Greenwich Community Association Inc
Submission to the NSW Department of Planning and Environment

Concept State Significant Development Application SSD 18_9579
Sydney Metro Crows Nest Over Station Development

**Figure 2 – Proposed Crows Nest OSD building envelope (axonometric diagram) and future high-rise development in the St Leonards Town Centre (Sydney Metro’s EIS)**

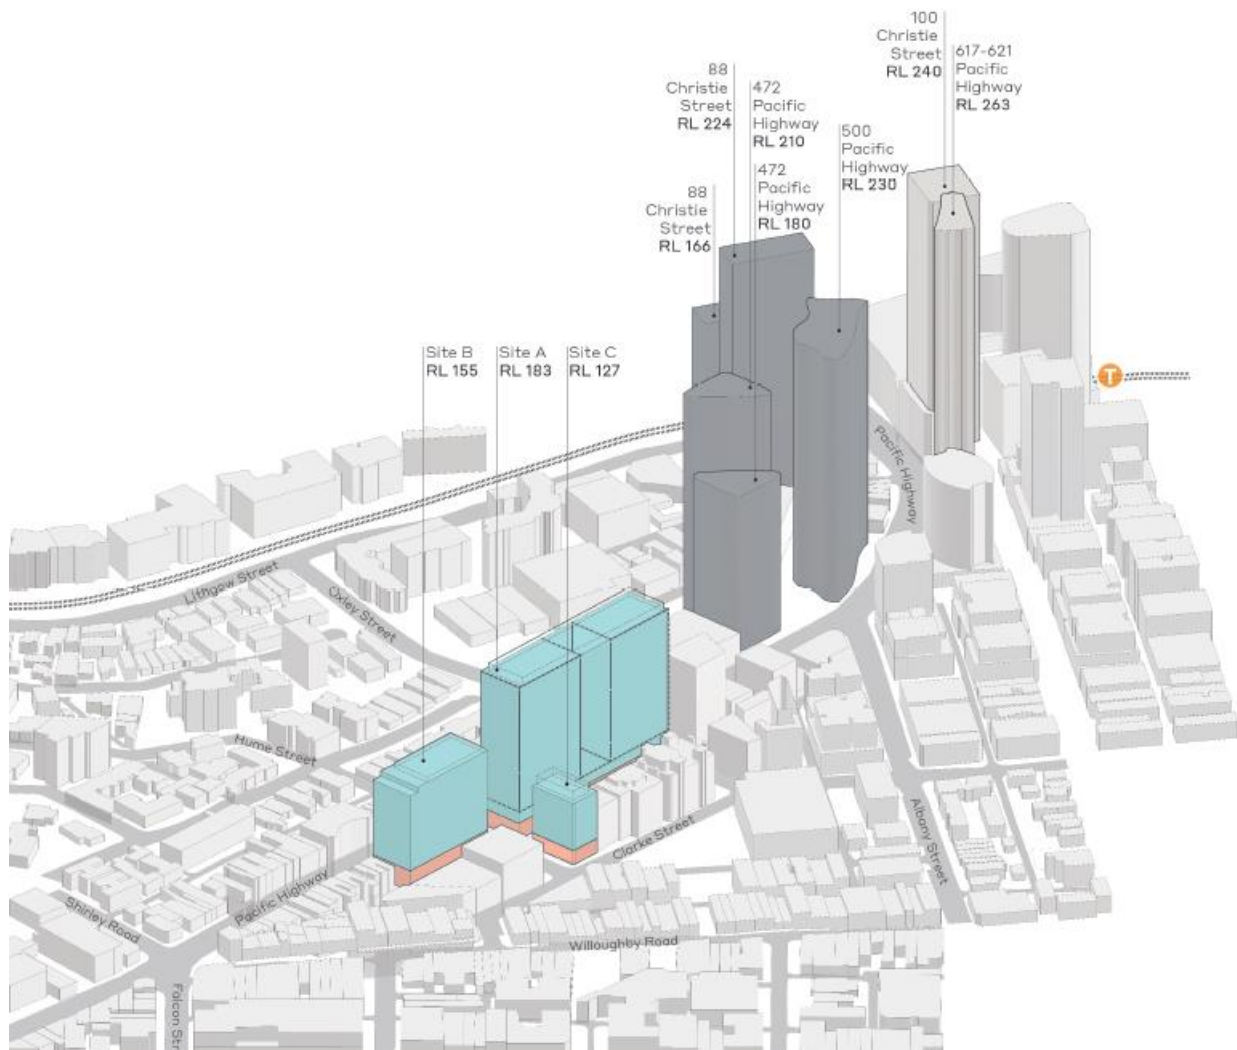
Misleading depiction of relative building heights in Figure 2 of EIS p 25

The axonometric diagram (at 45 degrees angle and south-east perspective) in Figure 2 on p 25 of the EIS ignores perspective and appears to have been included selectively to show that the proposed buildings over the Crows Nest Station are relatively small when compared to future and existing high-rise developments in St Leonards.

The tower at 472 Pacific Highway is at RL 180 roughly the same as the two 27 storey towers proposed in the OSD (RL 183) and as a result the two towers would look very much taller than depicted in this distorted image.

The depiction in Figure 2 should be contrasted with the more accurate depiction of the scale of the development in Figure 38 on p 98 of the EIS.
